Planning Application Ref: A/104/19/RES

Location: Crete Nursery, Dappers Lane, Angmering, BN16 4EN

Description of works: Approval of reserved matters following A/178/17/OUT for the demolition of existing outbuildings with retention of existing dwelling & erection of 6no. dwellings

Plate 2: Garden & Boundary Fences

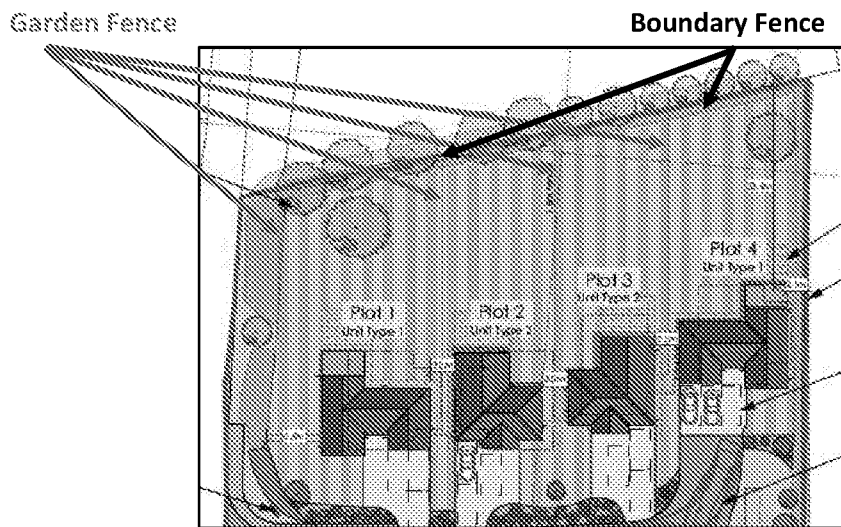
Para.3 - The AMS does not cover in enough detail what is happening with the boundary fencing and garden division fencing within the RPA of the screen of hornbeam trees to the north and off-site – mitigation measures and methodology required here.

Plate 4: RPA of T07 in Relation to the Existing Hardstanding Access Track
Dominant Category A Oak Tree (T07) With 9.15m RPA Superimposed

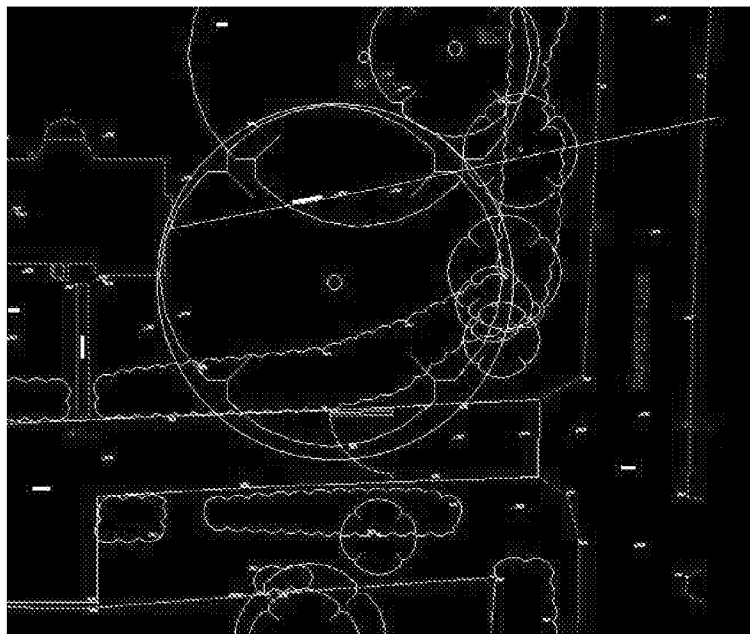
Para.4 – The AMS does not detail exactly what is happening and the mitigation measures and methodology required here for any revisions to the access drive (widening or resurfacing) that appear to be taking place.
